CITY OF ALBUQUERQUE

August 20, 2014

**RE: Eagle Crest Subdivision
Drainage Report and Grading and Drainage Plan
Engineer's Stamp Date 8-19-2014 (File: C18D064B)**

DRAWING NO.
DRB 3.0

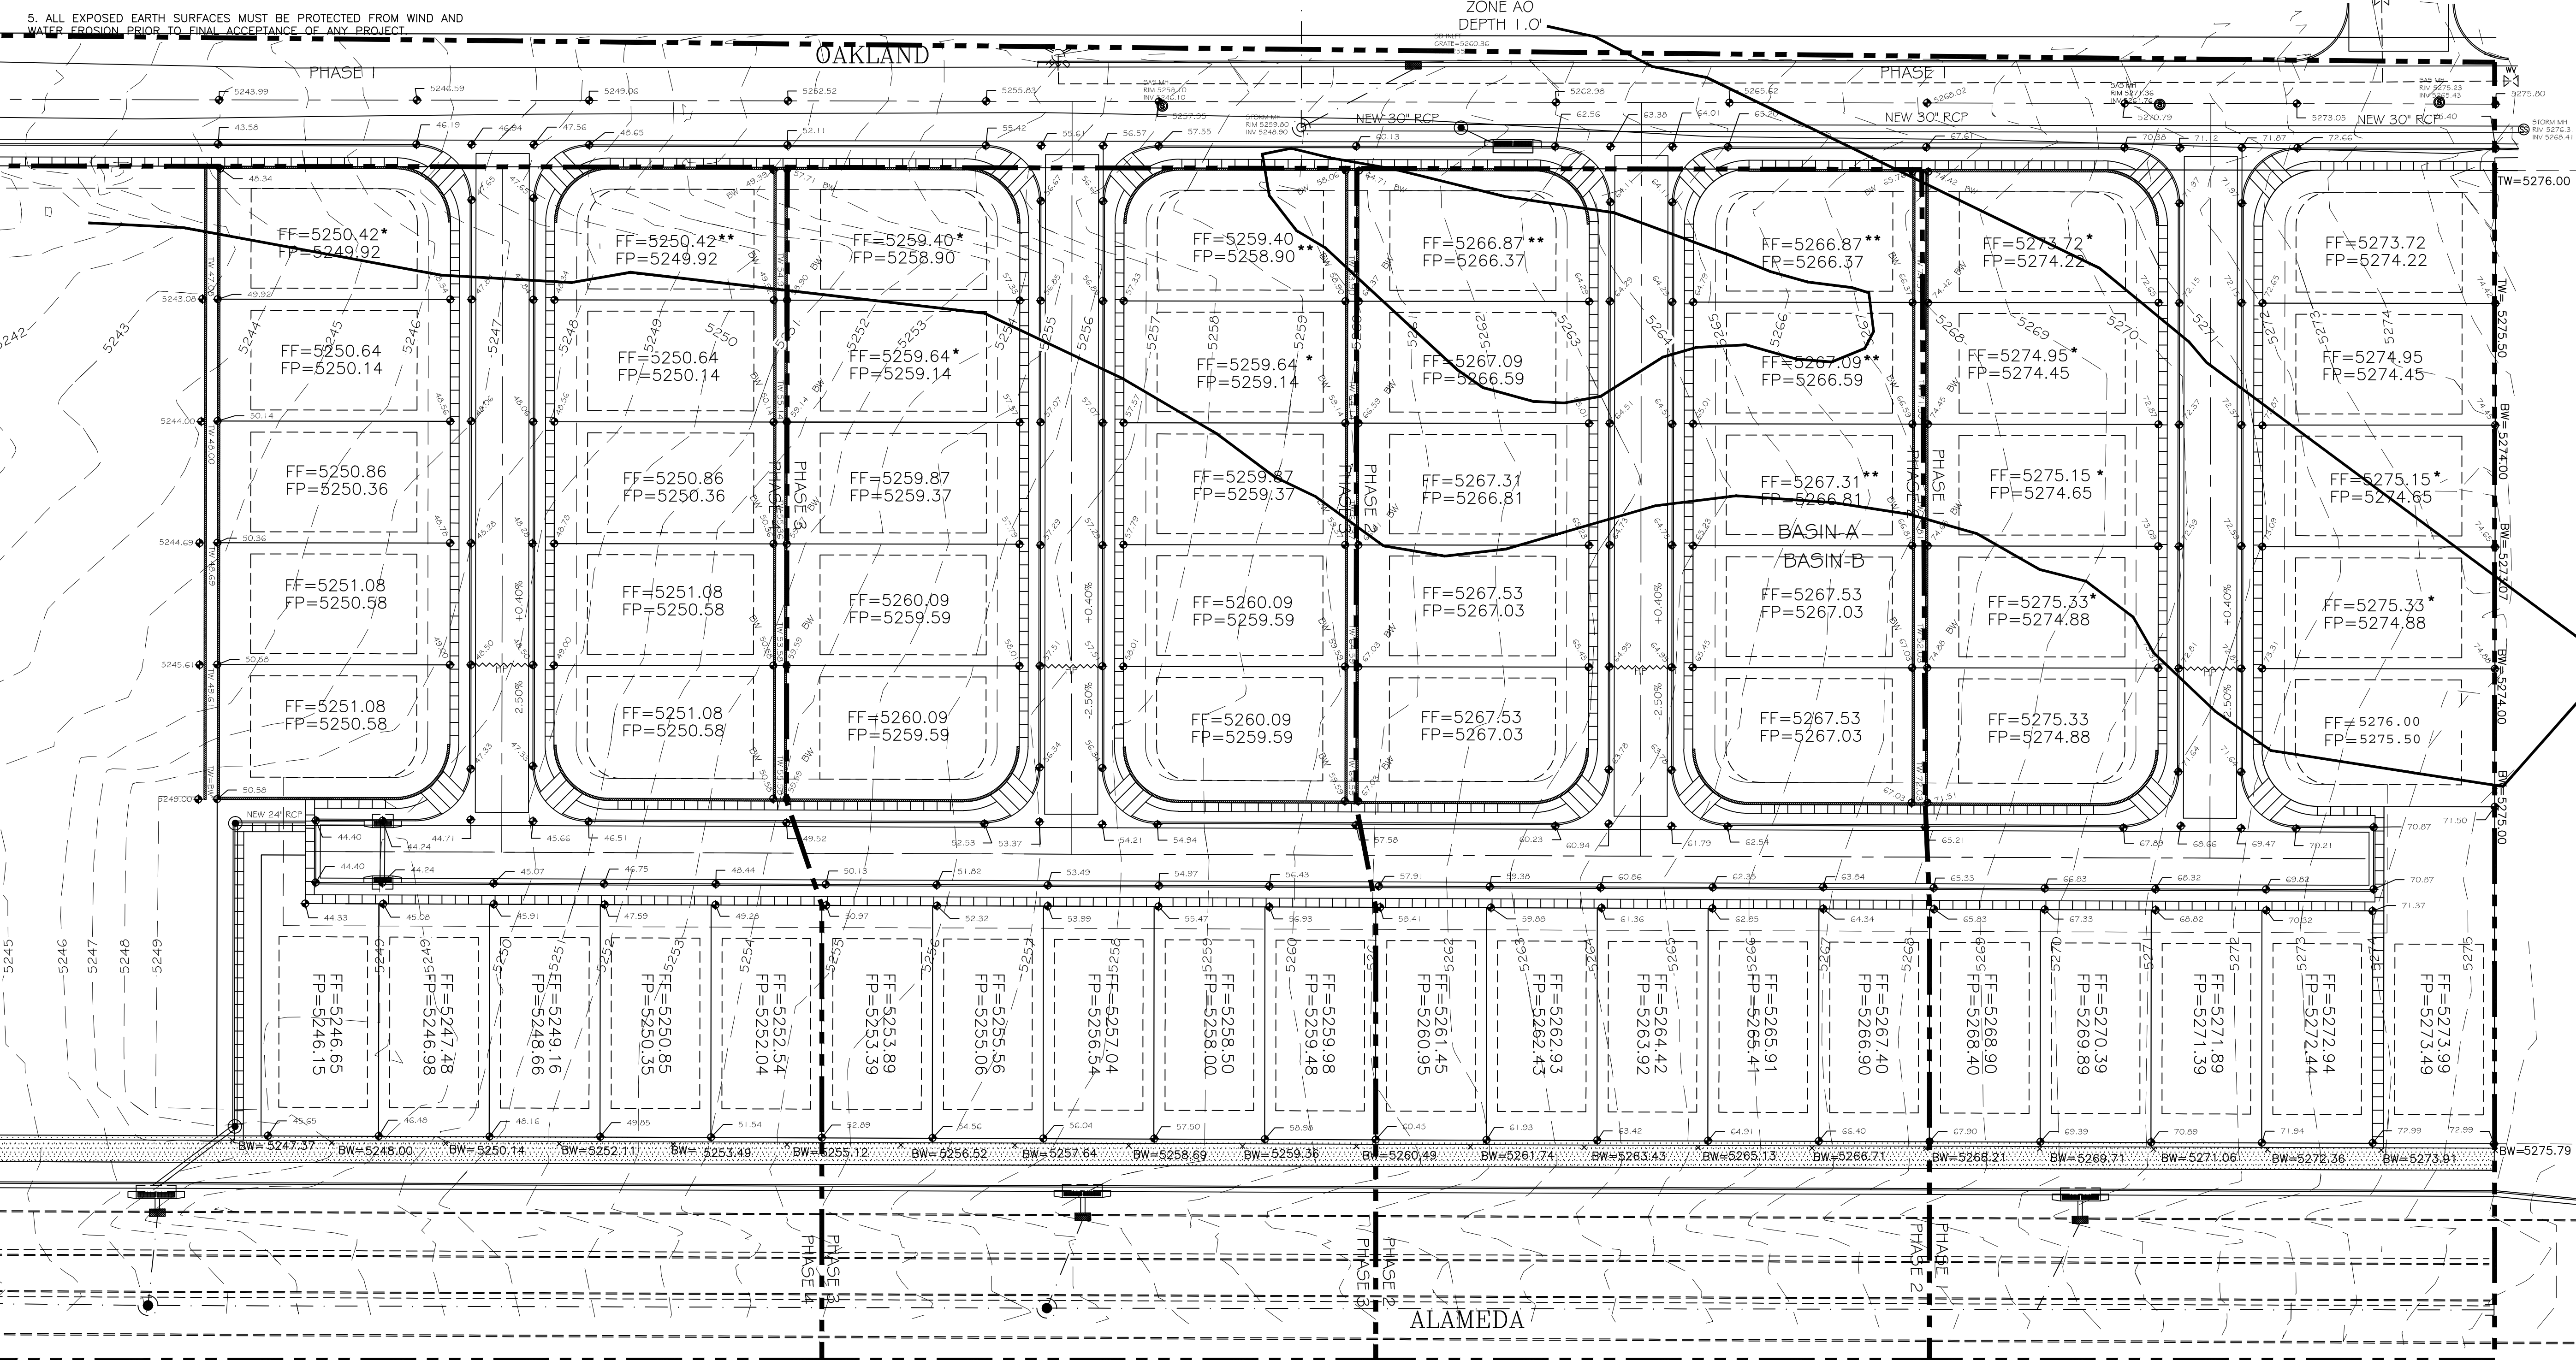
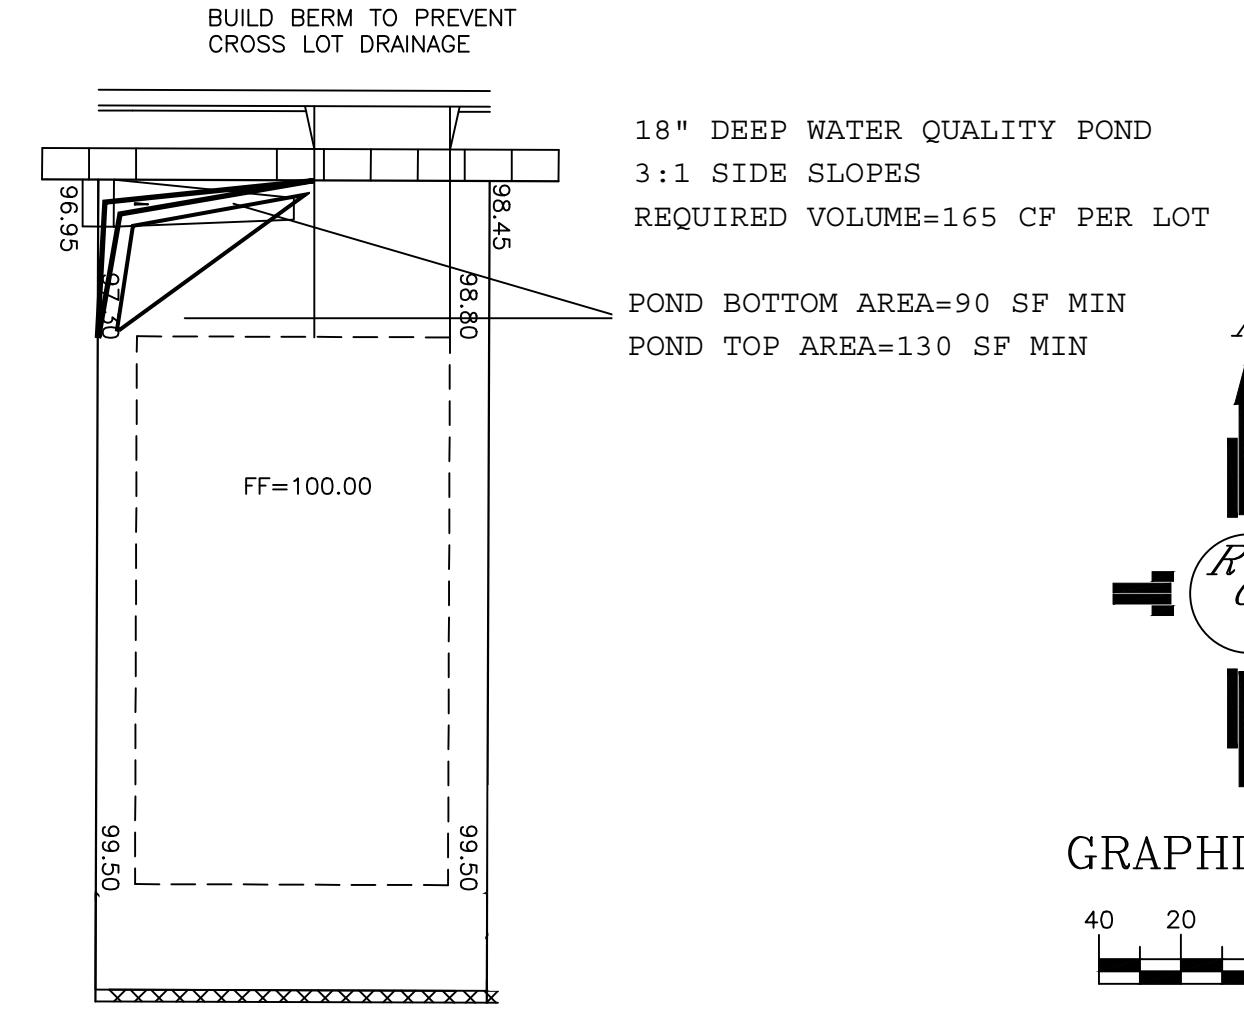
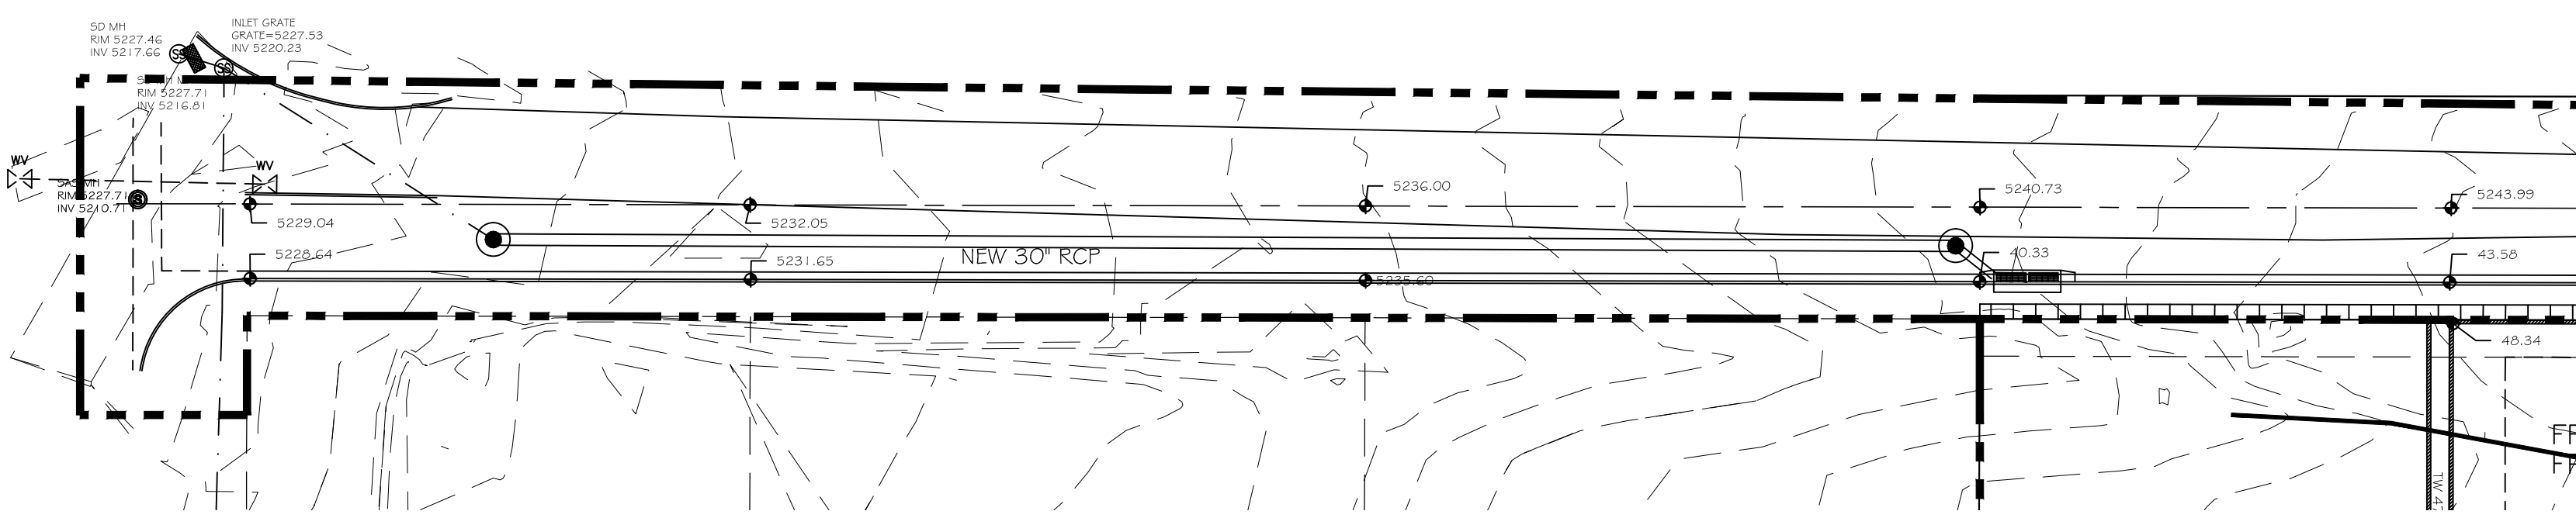
Please note that ~~since~~ the lateral pipes in Alameda are shown as 30" dia. RCP in more recent plans (as opposed to 24" RCP from earlier plans). Forthcoming as-builts should confirm this. Also, the storm drain from Soaring Avenue to Alameda (back of inlet) is sized as a 30" RCP in the report, and the DRC plans should reflect this.
